8<sup>th</sup> June, 2026

Planning Officer Assessments  
Housing Delivery Authority  
Department of Planning, Housing and Infrastructure  
Reply by portal: <https://majorprojects.planningportal.nsw.gov.au>

**SSD-89869959 10 Dangar Street Wickham NSW 2293**  
**EIS Public Submission**

# Ground Floor & Public Domain Plan

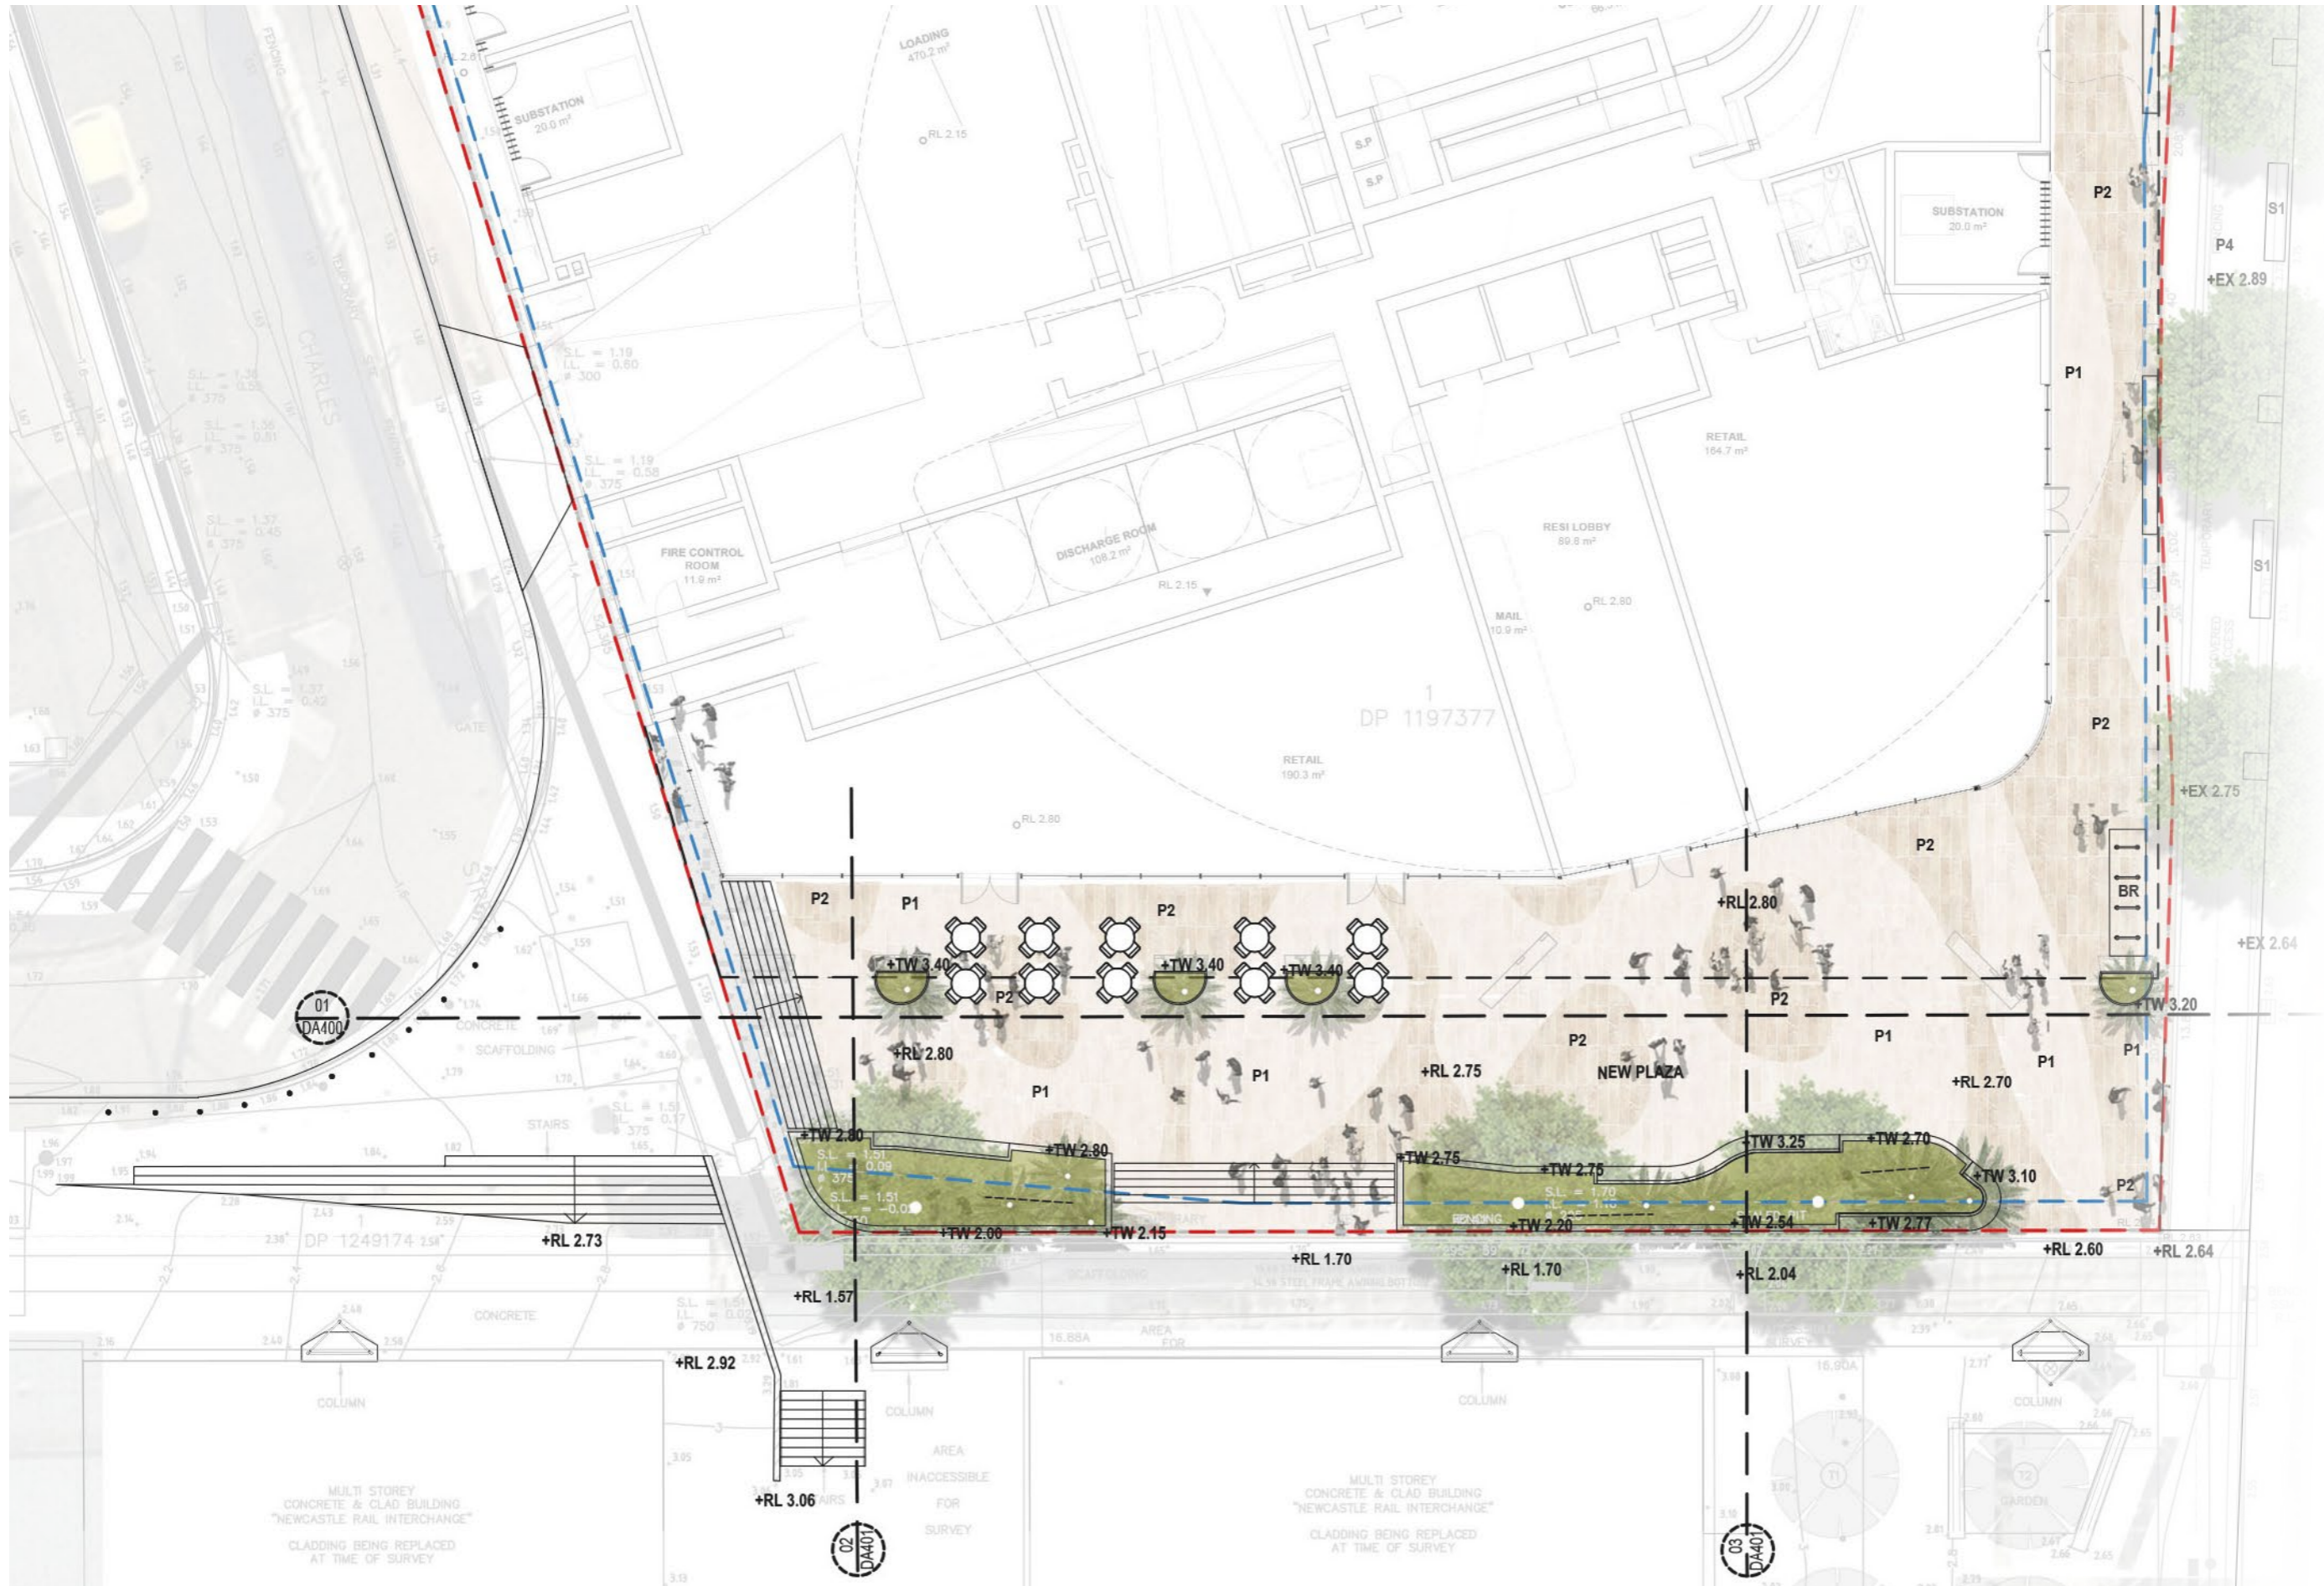
- The proposal provides **no public domain works**. The proposal proposes to “retained and protected” the footways along Dangar, Charles and Station Streets – this is NOT acceptable. Normal best practice is to remediate and/or upgrade to current standards. This was covered in consent condition 22 in the two previously approved DA’s. This consent condition must be imposed on this proposal.

- There is NO associated landscaping or improvements proposed within the public domain; that is, outside the site boundaries.
  - Along Dangar, Charles, Station and Hannell Street footways, Urban drawing LD-DA100\_1 says "Existing public domain retained and protected". That is, NO public domain improvement is proposed.
  - The existing footways are already damaged, so to simply say "retained and protected" is NOT acceptable.
  - Normal best practice is to remediate and/or upgrade to current standards. The two previously approved DA required this, at no cost to council. Consent Condition 22 for [DA2018/01197](#) is applied unchanged to the later approved [DA2022/00448](#). It reads:
